Goodman
Level 17
60 Castlereagh Street
SYDNEY NSW 2000

3 February 2016

**Re: Orica Southlands Industrial Estate Project Approval 060191
Review of Turning Head Hydraulic Modelling Assessment**

(a) As-Con with Turning Head at RL~3.85m (Scenario 1) Flow Depth

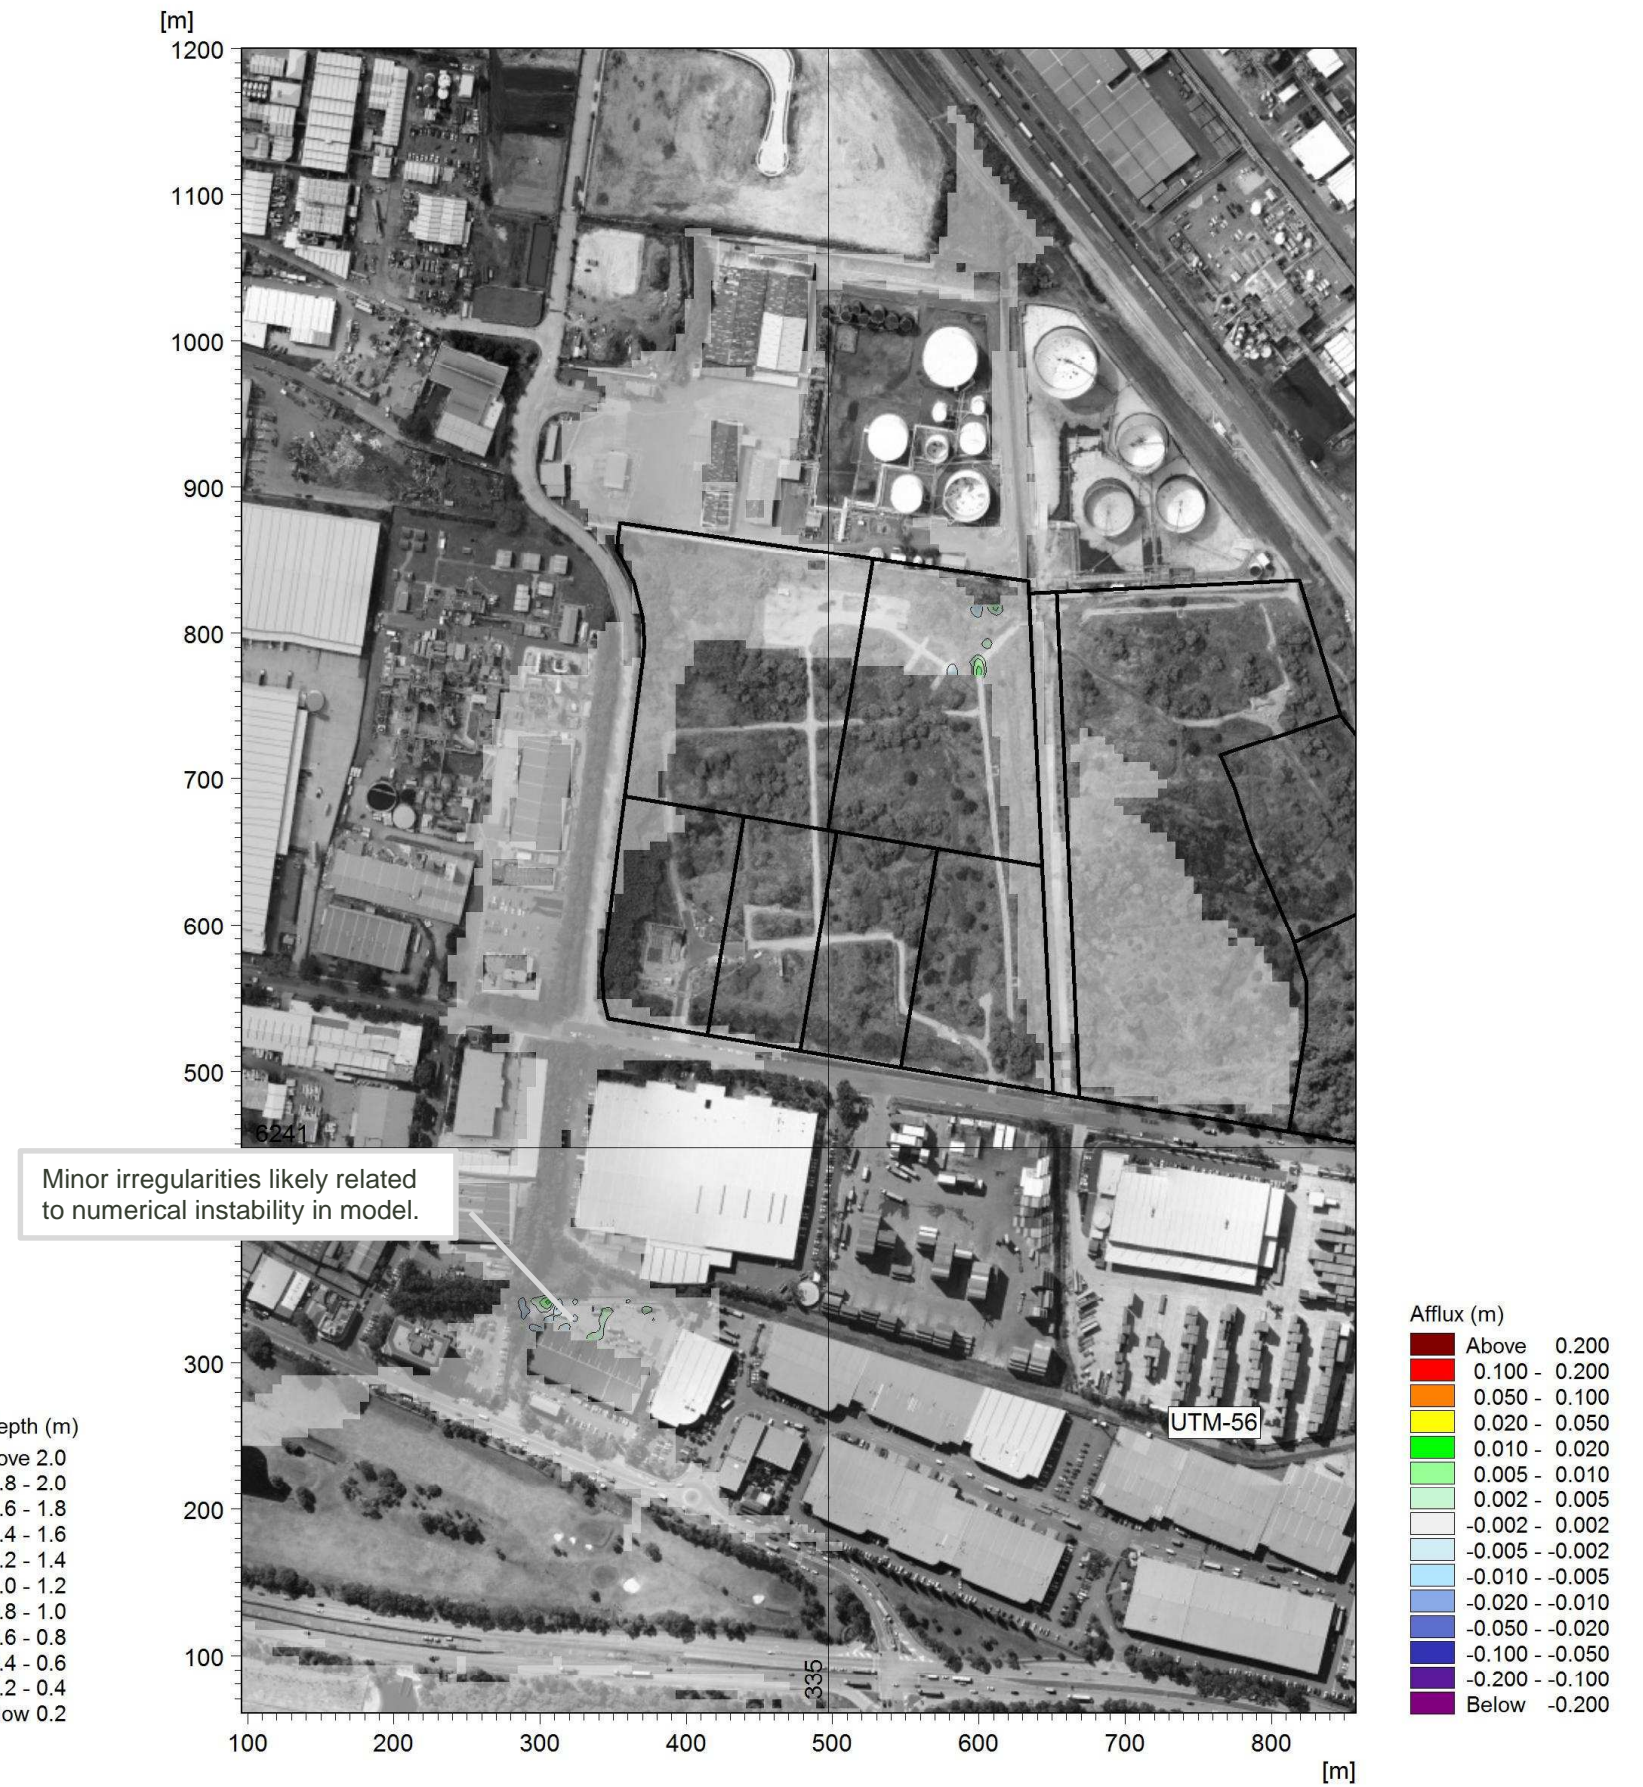
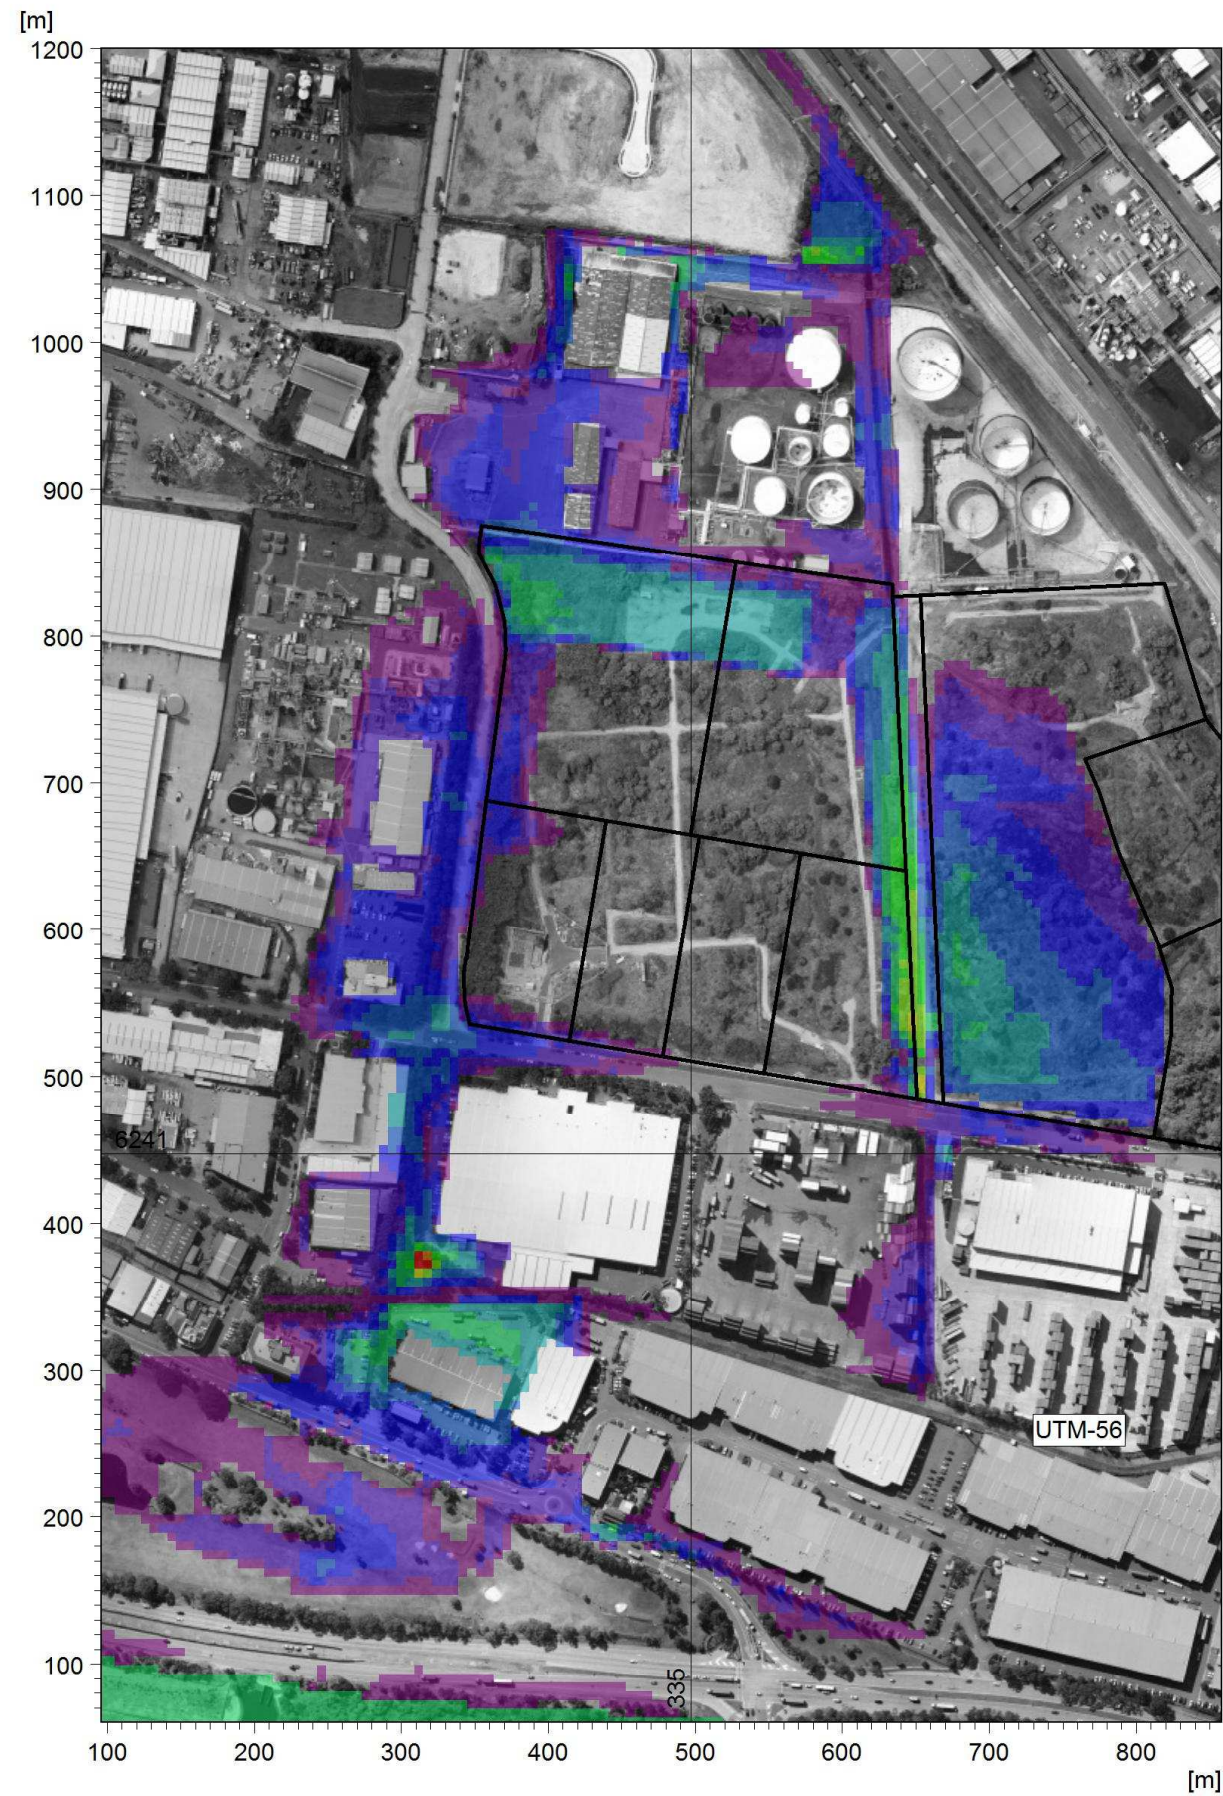
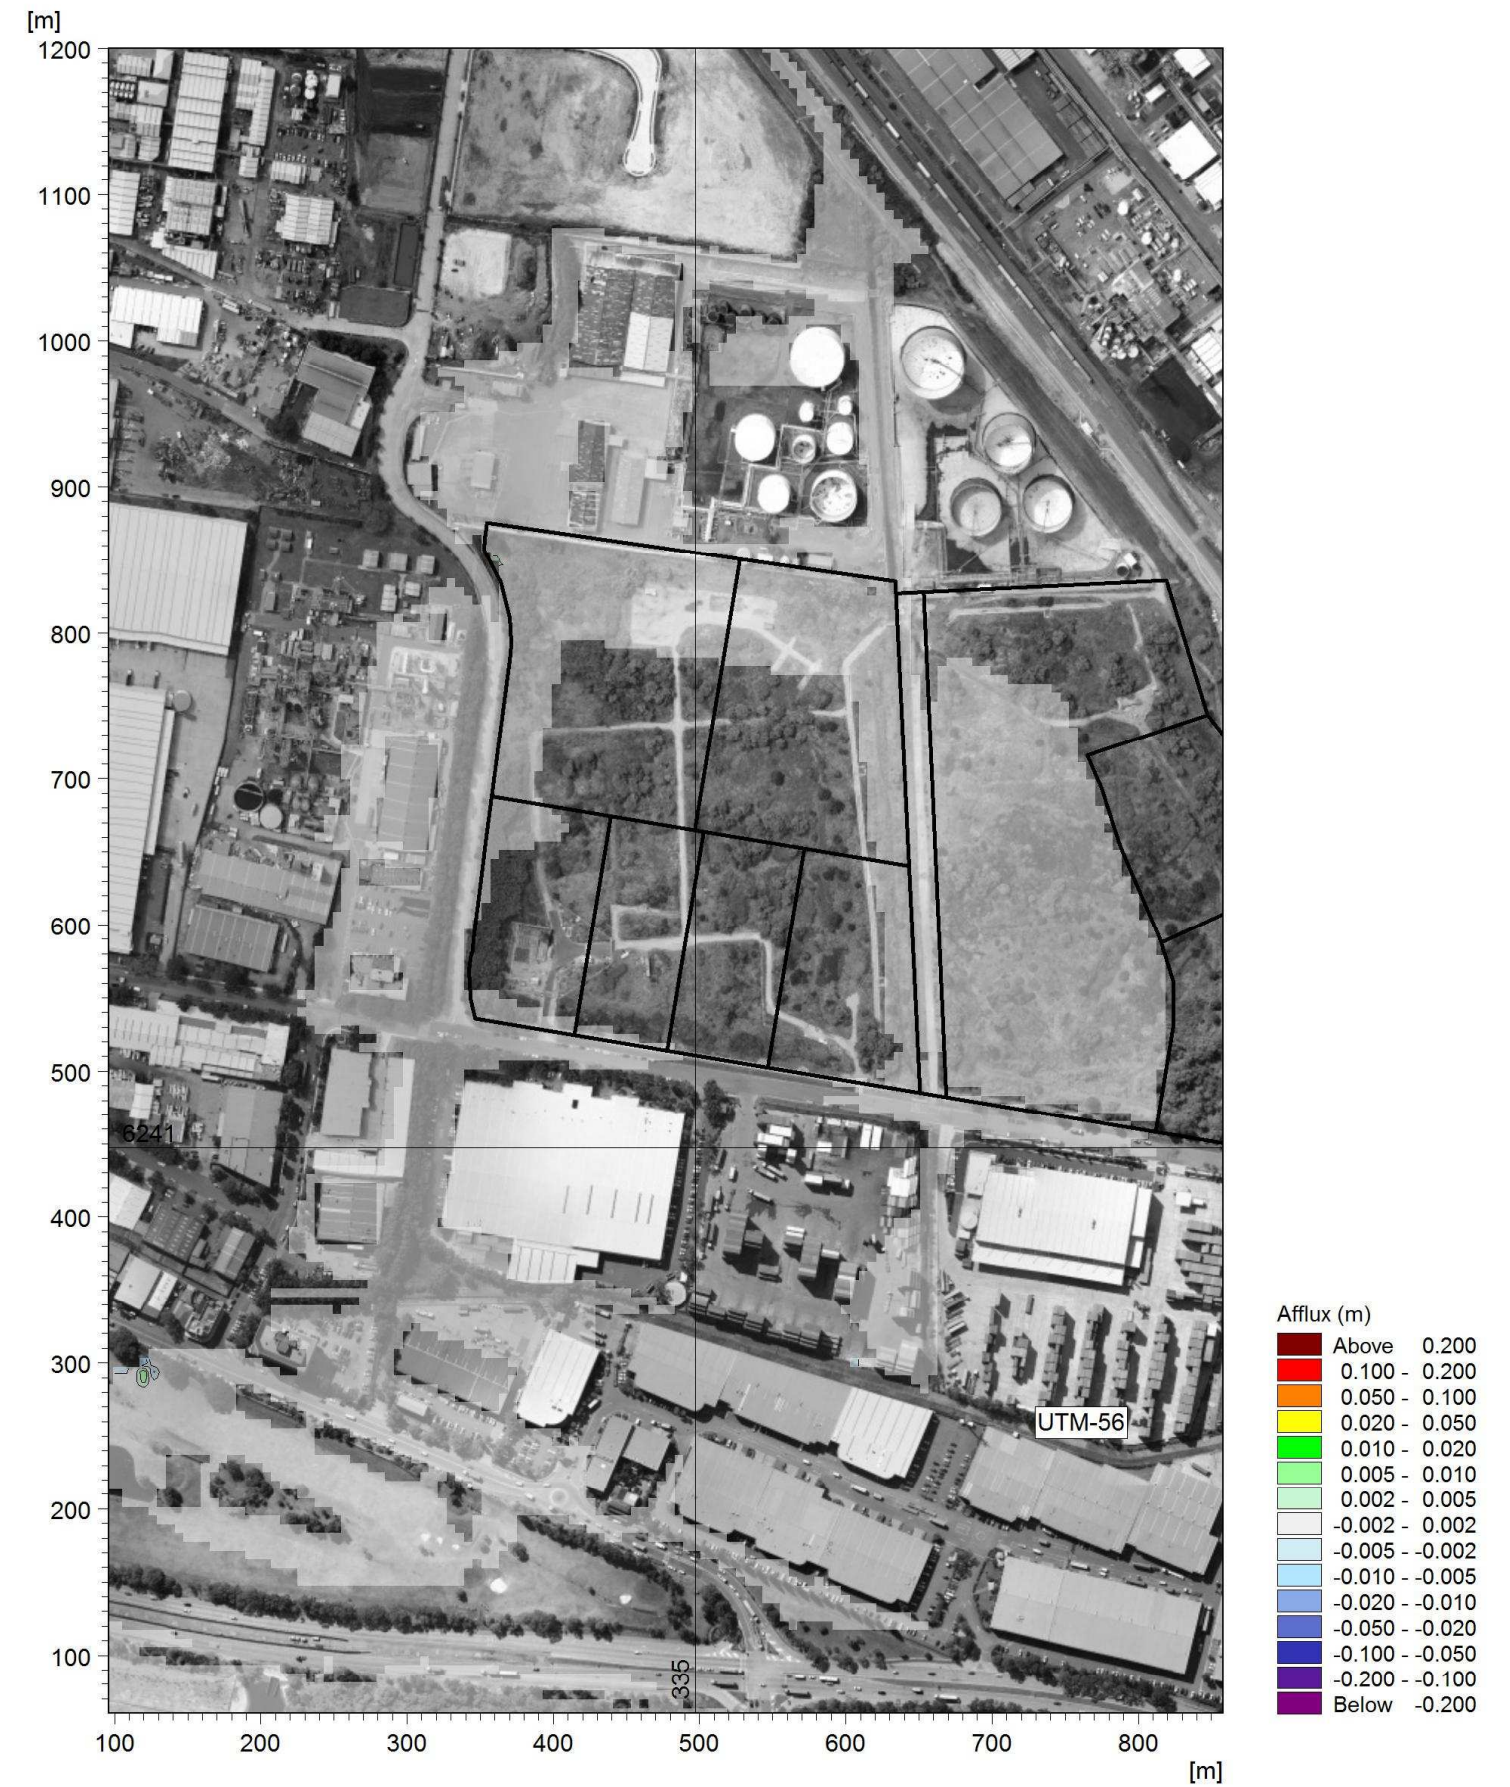
The turning head is below the 1% AEP flood level however the proposed height is acceptable for the following reasons:

- raising the level will cause unacceptable increases in flood level;
- the probability of a coincident fire and flood is very rare;
- flood depth warning signs will be provided and the fire service can make an informed decision regarding access should they attend during a flood.

Yes, taking into account the above comments, the “as constructed plus turning head” flood impacts are no greater than the nominated design flood impacts and Schedule 3 Condition 10 has been satisfied. Field survey of the constructed turning head should be undertaken and provided to satisfy Condition 10 c).
